**DESIGN AND ACCESS STATEMENT IN RESPECT OF  
AN OUTLINE PLANNING APPLICATION FOR RESIDENTIAL DEVELOPMENT  
ON FORMER GARAGE SITE, FOUNTAIN CLOSE, DARTON, BARNESLEY**

Subject: **Asset Disposal and Investment Programme  
Fountain Close Garage Site, Darton**

SITE LAYOUT 1:200,

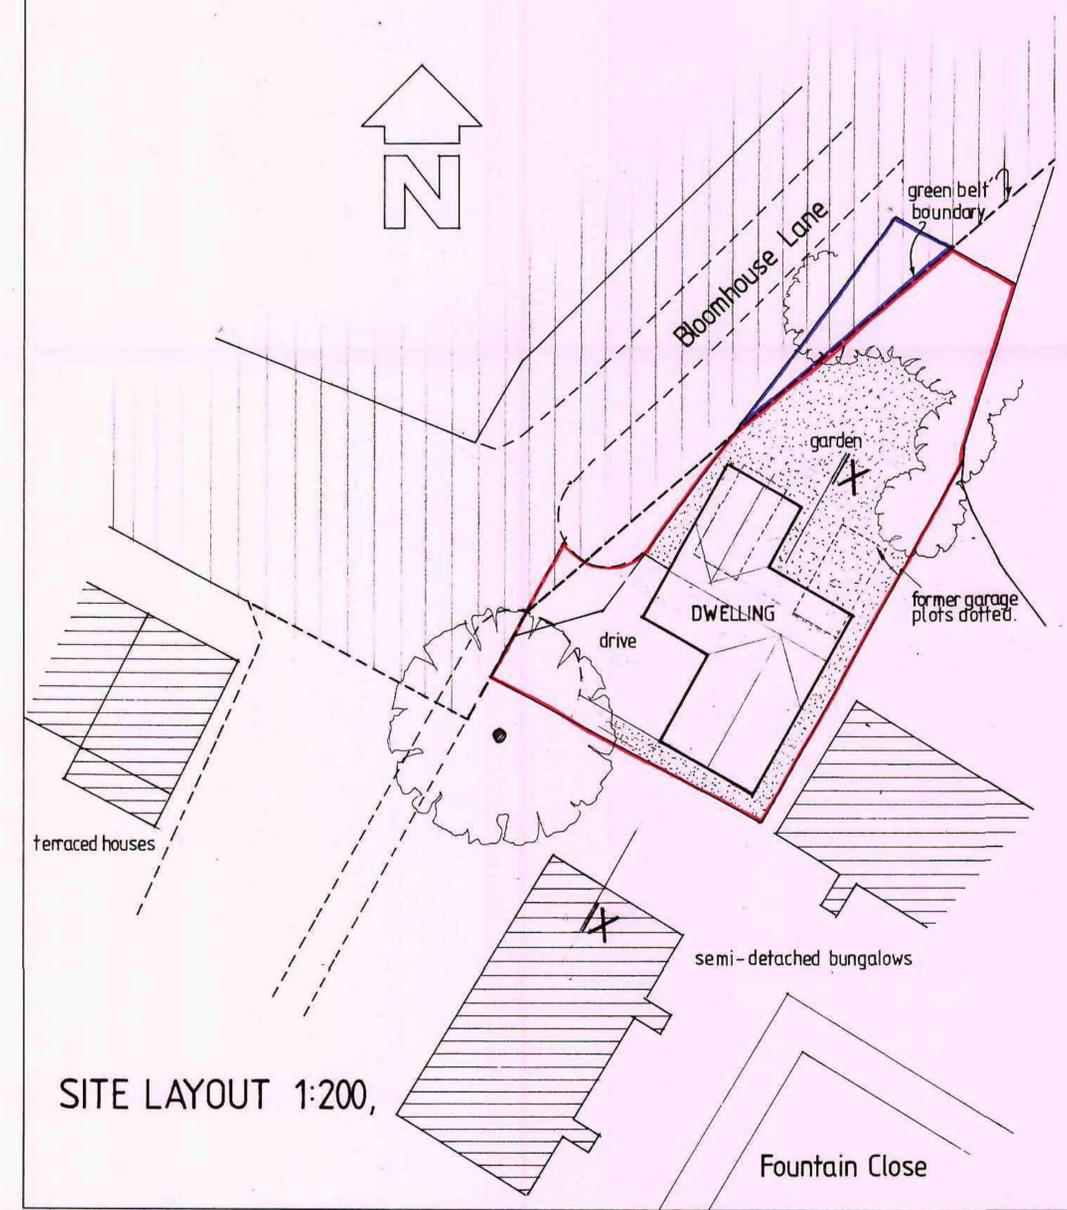
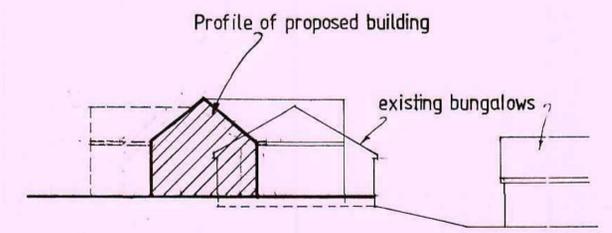
Any development must provide an on site turning area to prevent vehicles reversing on/off the public highway, to the detriment of road safety.

A small corner of the site extends into the green belt. If the site is to be developed, this land should not be included in the developable area, or used as garden. I have attached a plan to indicate the extent of the green belt in the vicinity of the site.

It would be desirable to retain as many trees as possible on the site. The development should incorporate some tree planting to compensate for any loss of trees on the site. The large sycamore immediately adjacent to the site entrance (but outside the site) must be physically protected from damage during construction.
